OXFORDSHIRE COUNTY COUNCIL'S RESPONSE TO CONSULTATION ON THE FOLLOWING DEVELOPMENT PROPOSAL

Application no: 21/02893/REM

Proposal: Approval of reserved matters pursuant to condition 1 of planning permission 18/01894/OUT for details of layout, appearance, scale, landscaping, access and parking for 25 dwellings

Location: North Of Shortlands And South Of High Rock, Hook Norton Road, Sibford Ferris

### Vehicle and Cycle Parking

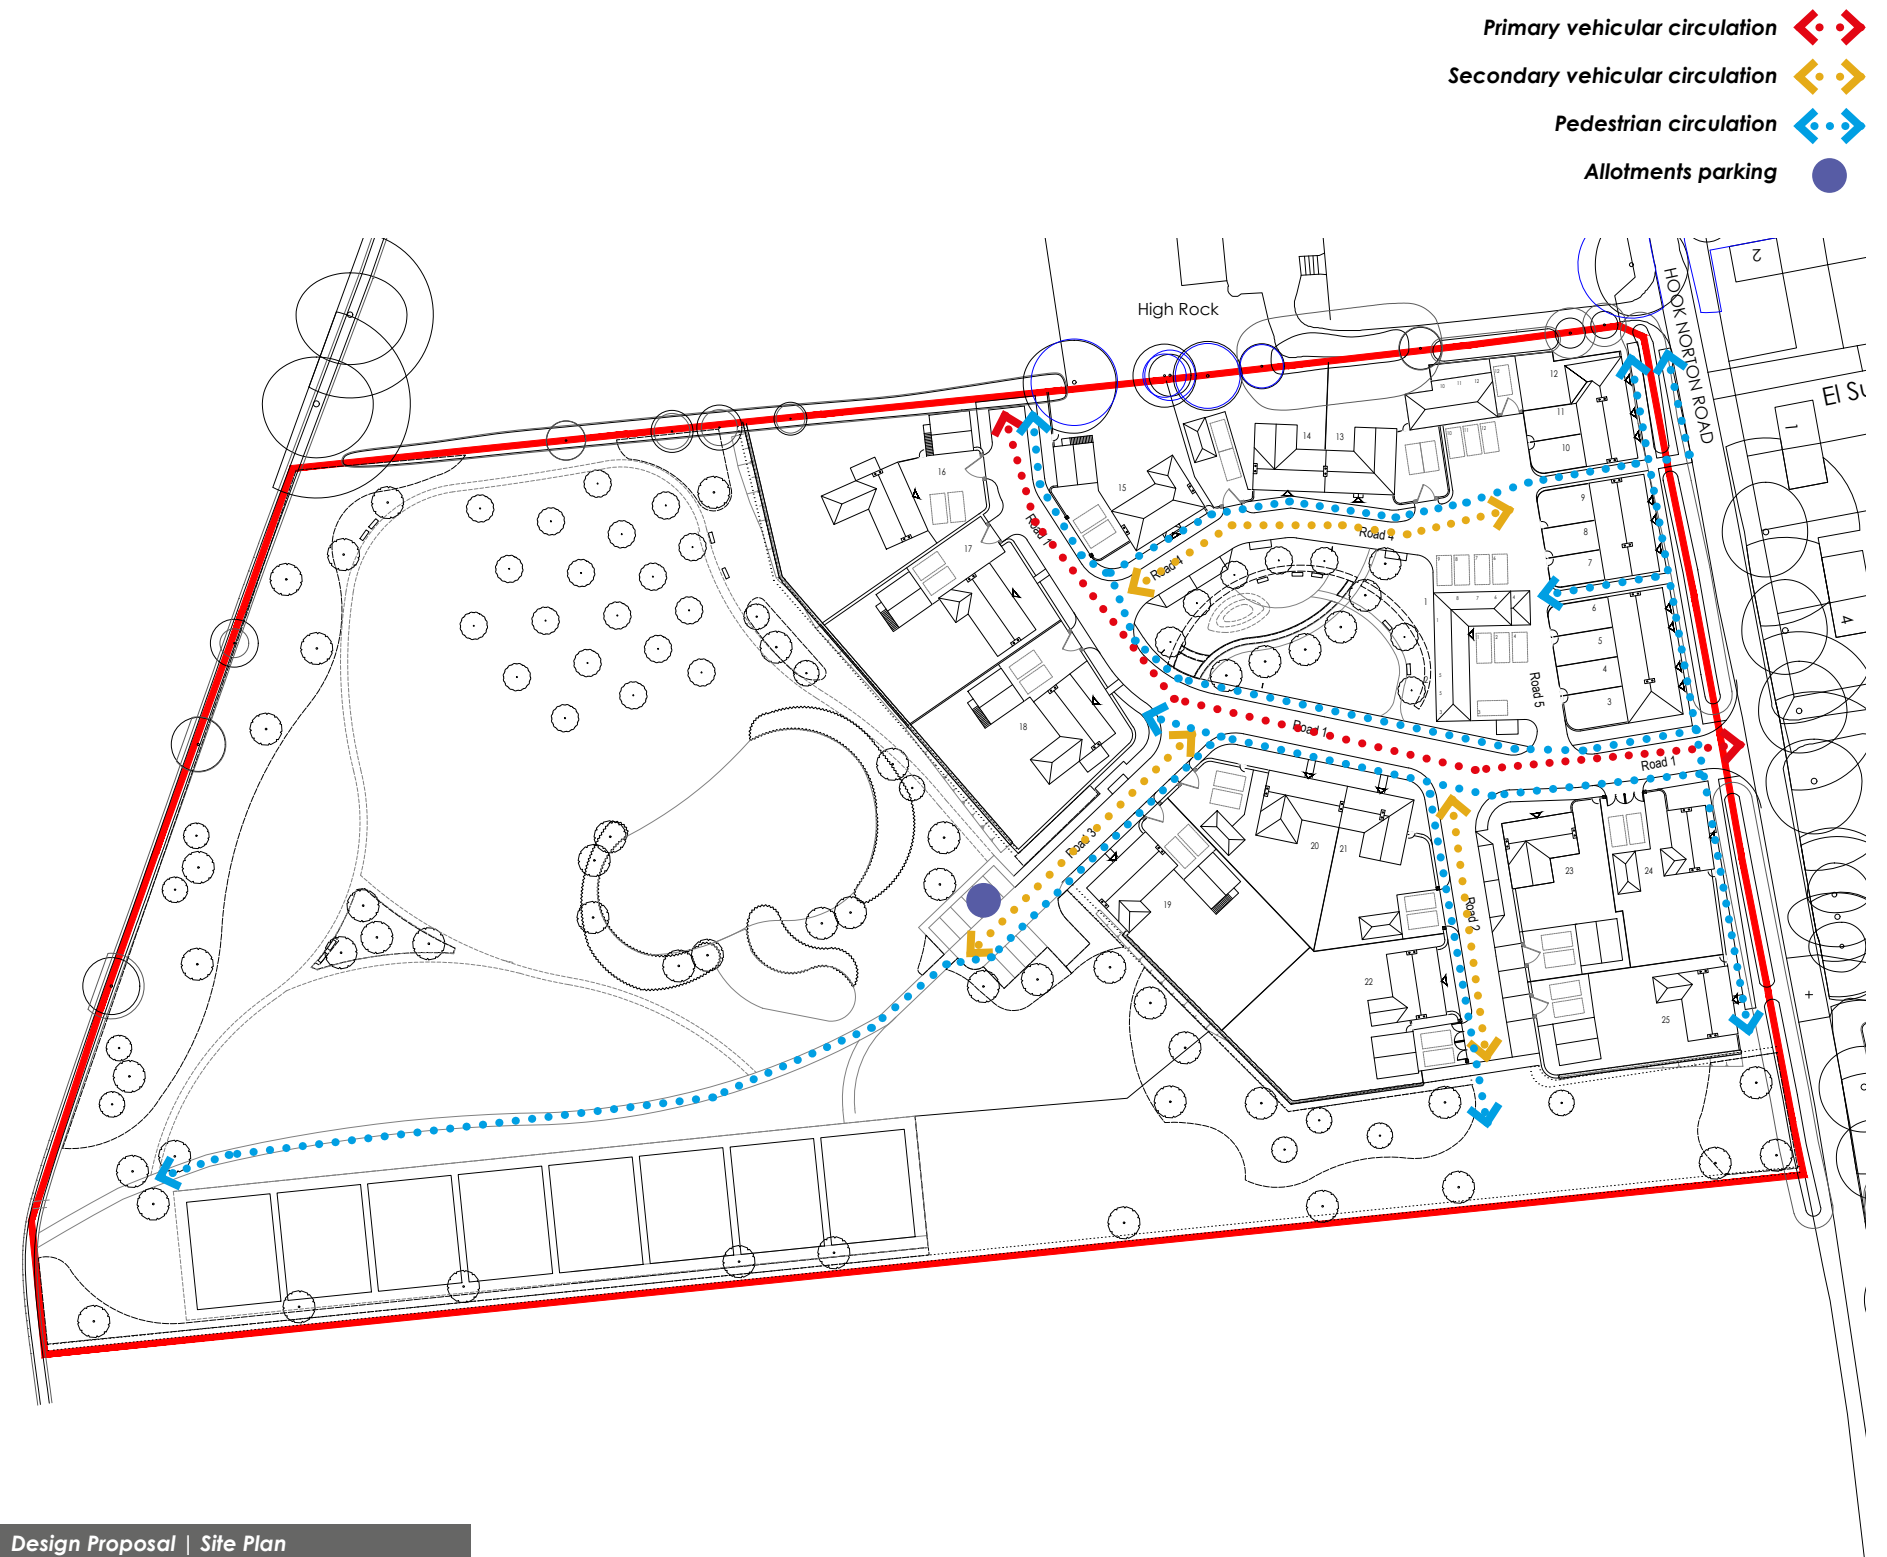
- **There is no turning head at the end of Road 2**

Road 2 serves the parking spaces for four dwellings, as well as two unallocated parking spaces. Any vehicles entering this road will not be able to turn unless they are actually using one of the private off-road spaces. This means that any delivery vehicles, visitors to the dwellings, vehicles using the unallocated spaces, etc. will have to reverse out of Road 2 and across both lanes of Road 1 in order to leave the development. Apart from the inconvenience this will cause, there will also be an unacceptable highway safety risk.

The two one-bedroom flats have one parking space and all the other residences have two, which is in accordance with OCC parking standards. The larger dwellings also have garages. There are fourteen unallocated visitor parking spaces within the development, again in alignment with standards. Unfortunately, though, these are not well distributed throughout the site as ten of them are grouped at the end of Road 3. This road does appear to have a turning area which will be required if all spaces are occupied.

I am concerned about the pedestrian routes to Plots 3 to 12, 24 and 25. Any visitors to these properties who arrive in a vehicle, particularly grocery deliveries or similar, will wish to park up as close to the north-south path as possible, and this will be very near to the bellmouth junction. It is unlikely that such deliveries will seek out the visitor spaces as they are hidden from view down side roads and/or too far away to be practical for deliveries. It would be a significant benefit to the development if visible visitor parking could be incorporated along Road 1, where it is most needed.
